Rezoning Transportation Analysis

Petition Number: 2022-209

Date	Description
4-27-23	First Review (PDM)
5-24-23	Second Review (DR)
6-21-23	Third Review (DR)

RZ 1.0

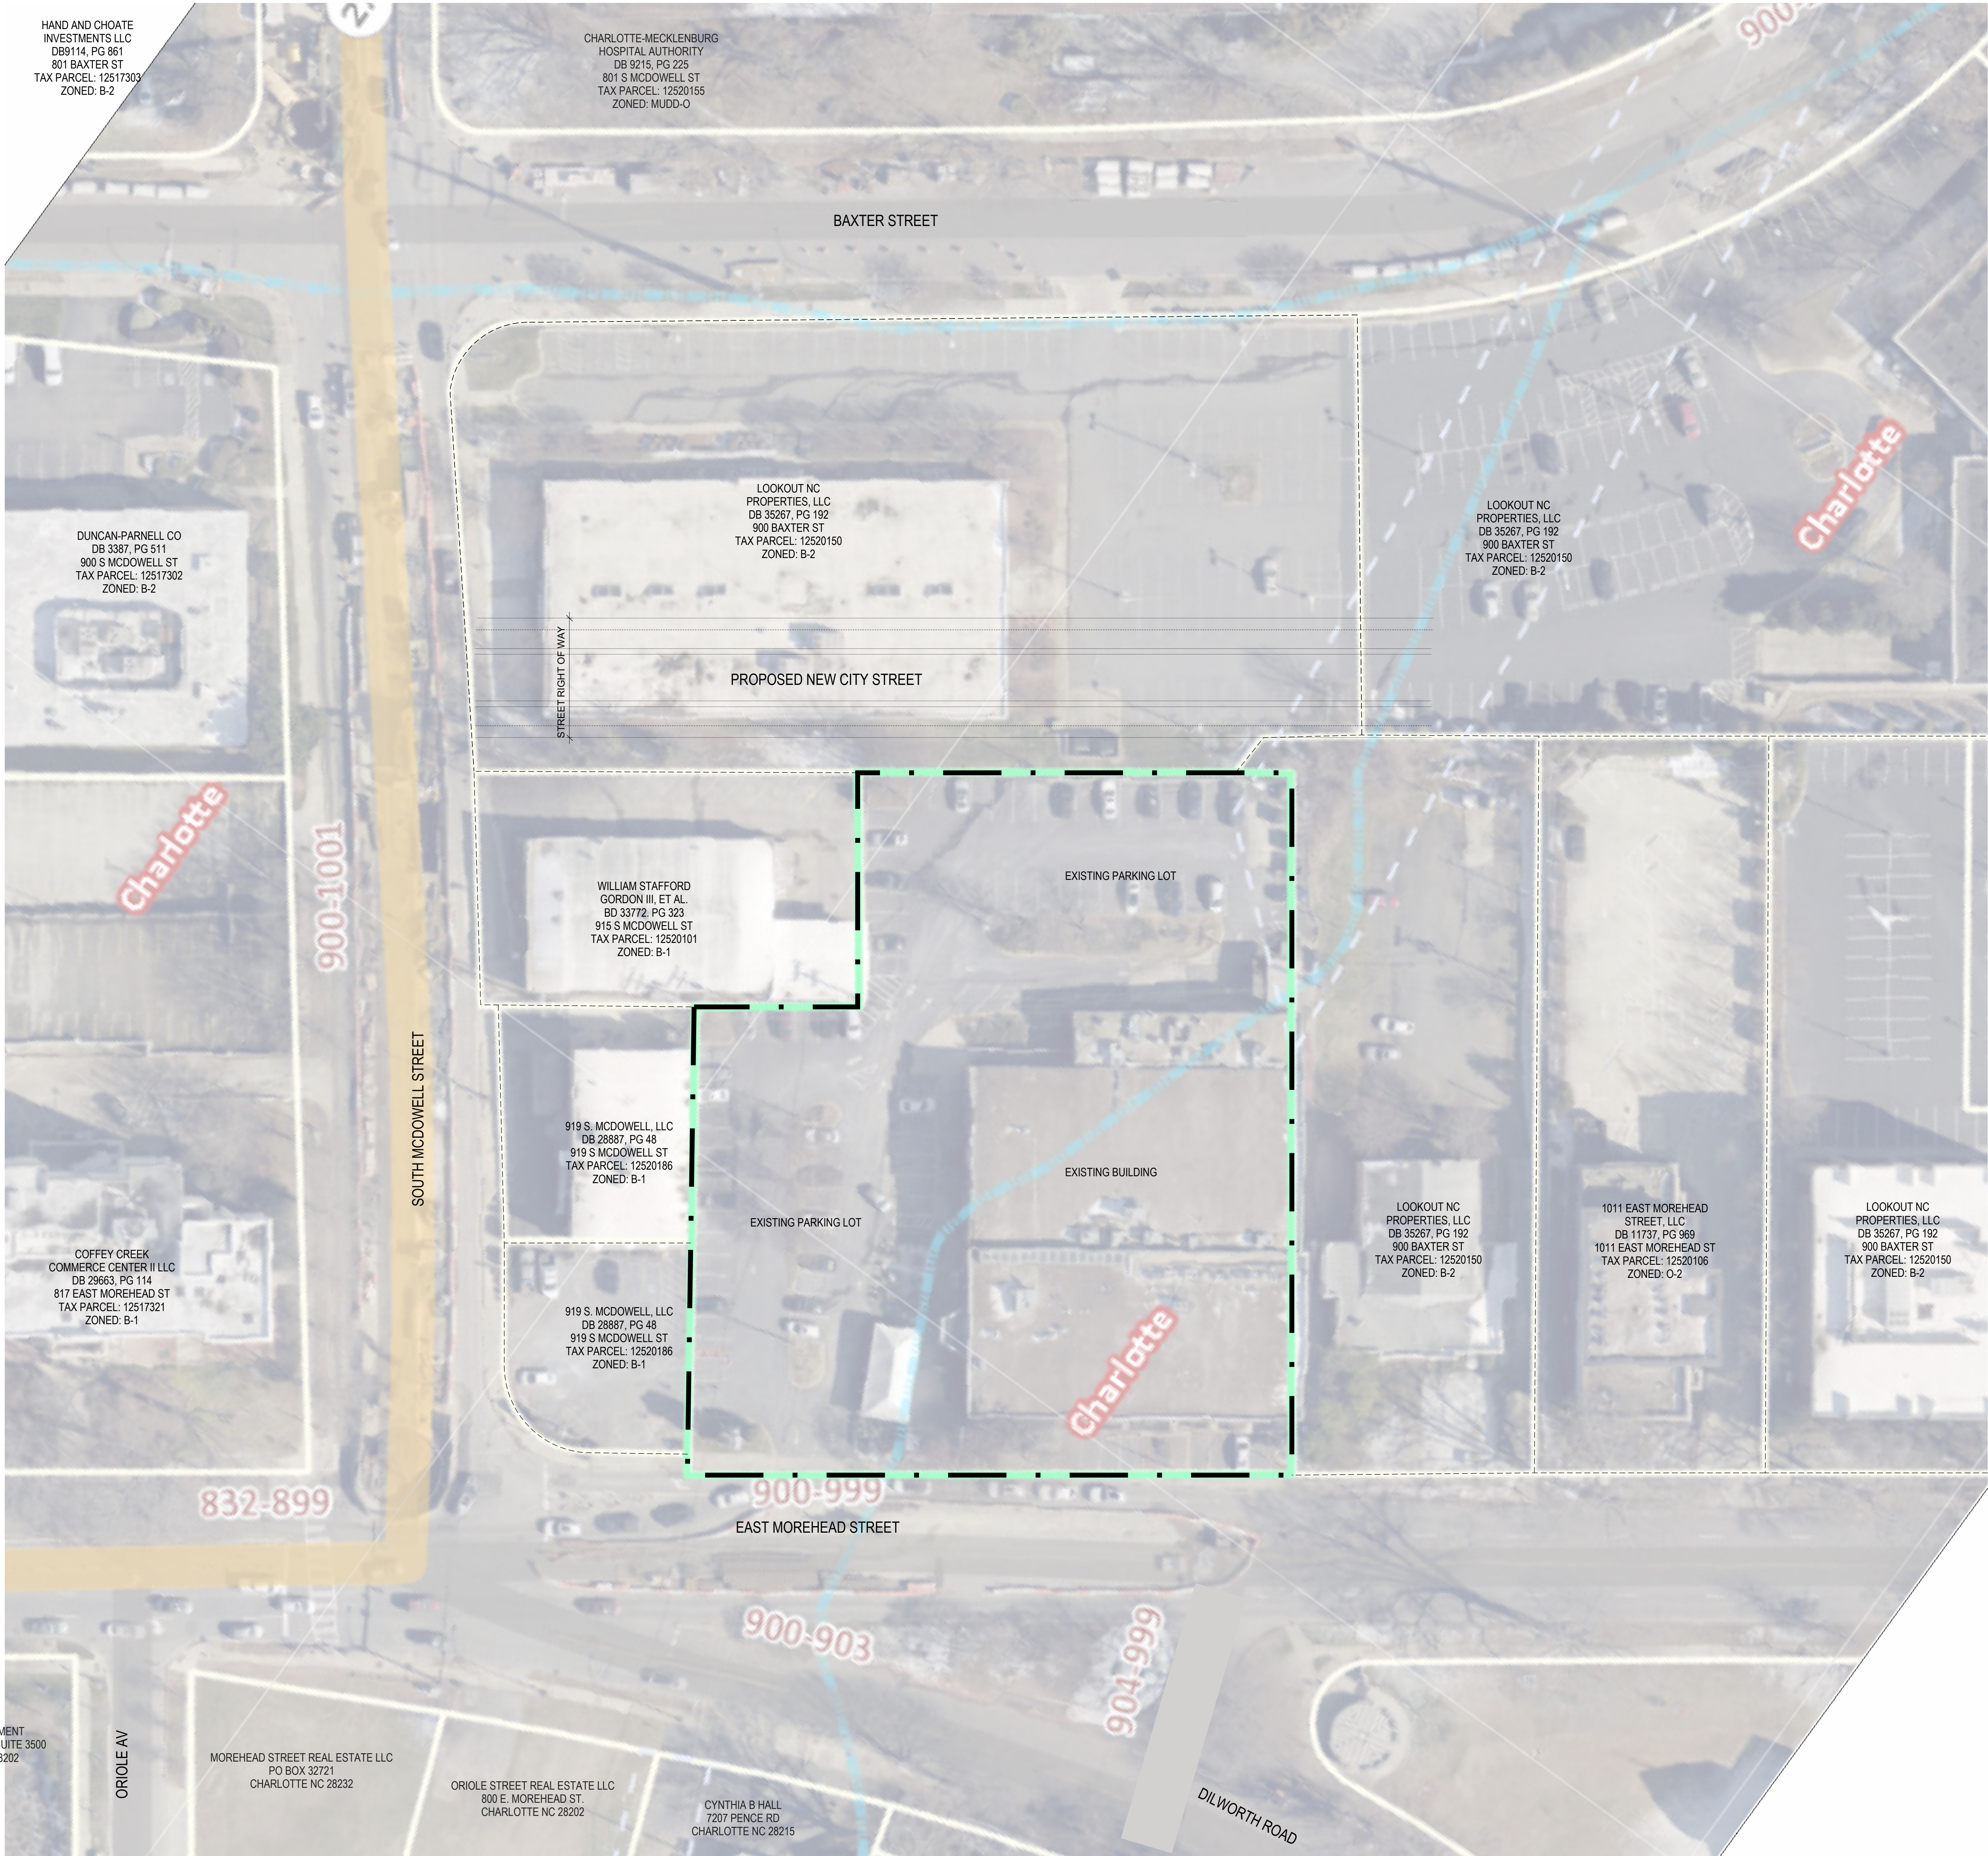
~~**Morehead Street:** Location of curb and gutter to be moved to 38 feet from roadway centerline to accommodate the Charlotte Streets Map with a roadway typical section of a four plus avenue with buffered bike lanes.~~

~~Label and dimension the curb and gutter from the centerline for each road on the site plan.~~

- ~~3. Revise site plan and conditional note(s) to commit to dedicate a minimum of 40 feet of right of way from the road centerline. The site plan shall label and dimension the right of way from the road centerline. In addition, provide sidewalk utility easement if the proposed sidewalk facility will be located outside of the ROW.~~
- ~~4. Revise site plan and conditional note(s) to extend the existing concrete median along Morehead to the Dilworth Road connector.~~

- ~~5. Revise site plan and conditional note(s) to commit to construct an 8-foot planting strip, and 8-foot sidewalk on Morehead Street per Chapter 19. The site plan shall label and dimension both items from the back of the future curb and gutter location.~~
- ~~6. Revise site plan and conditional note(s) to clarify who is constructing the offside proposed street, and that a cross access easement is required to access the street across private property.~~

- ~~7. Revise site plan and conditional note(s) to commit to construct bicycle facilities by locating the curb and gutter 38 feet from the center line to meet the Council-adopted Charlotte BIKES Policy.~~
